INDIVIDUAL PLANNING OBJECTION

Waterloo South SSDA — SSD-93222706

115 Cooper Street, Waterloo NSW 2017 — PT 2 — SP79210

Figure 1824: Carpark locations and entries

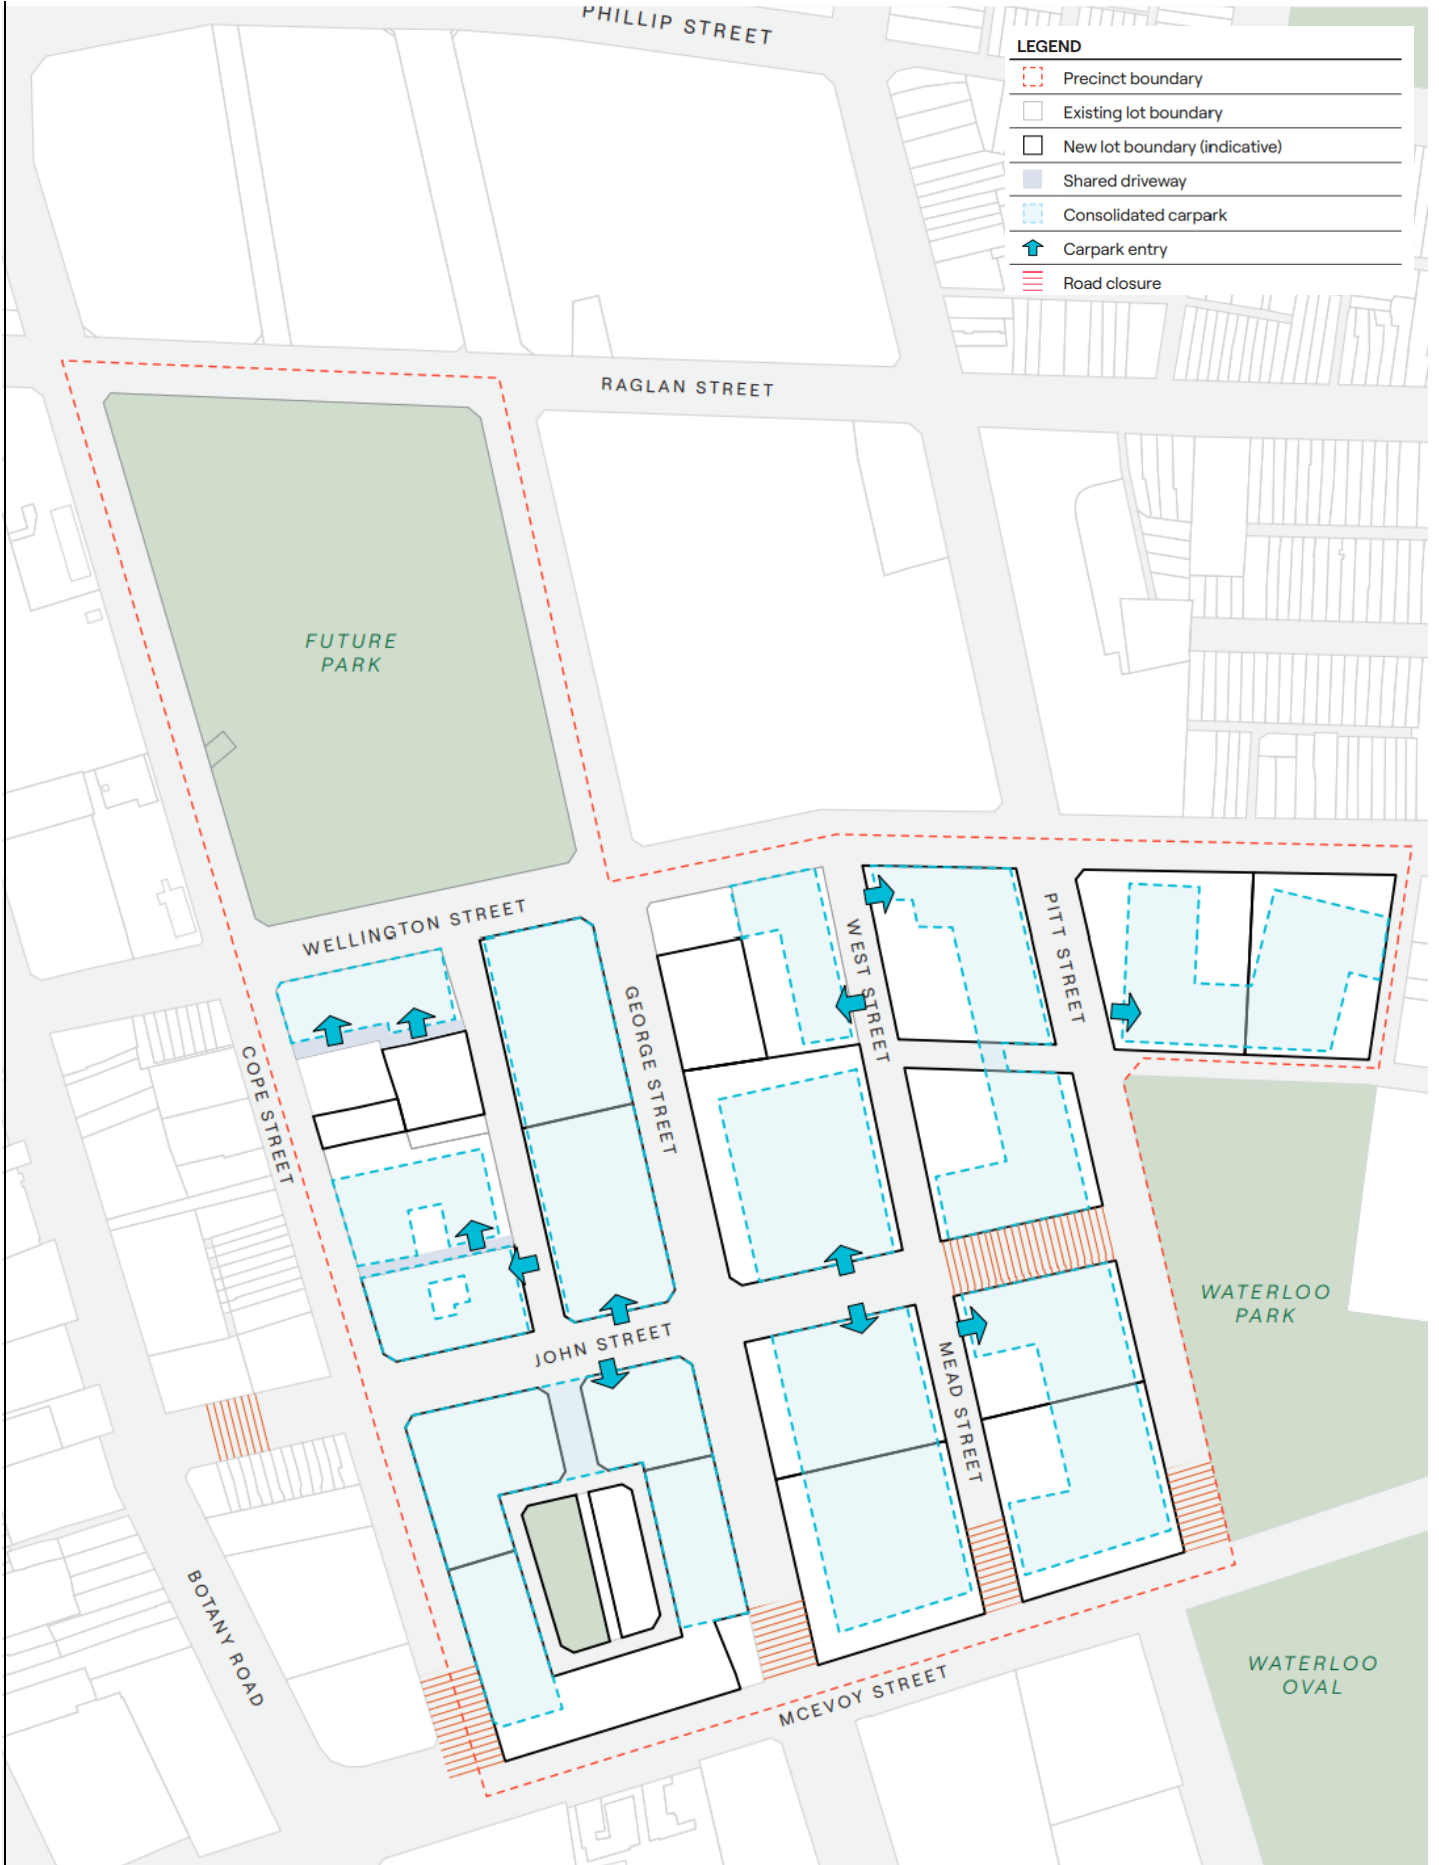
- **Carpark traffic and pedestrian safety:** The Block 2 consolidated carpark entry is confirmed on Cooper Street (Figure 49, Updated Waterloo South Design Guide, SJB Architects, 2026). My gated front entry opens directly onto the Cooper Street footpath — there is no buffer between my front door and the street. Introducing carpark traffic for a 9-storey residential building immediately beside residential front doors on a narrow footpath creates a foreseeable pedestrian safety conflict that has not been assessed in the EIS Transport and Access chapter.
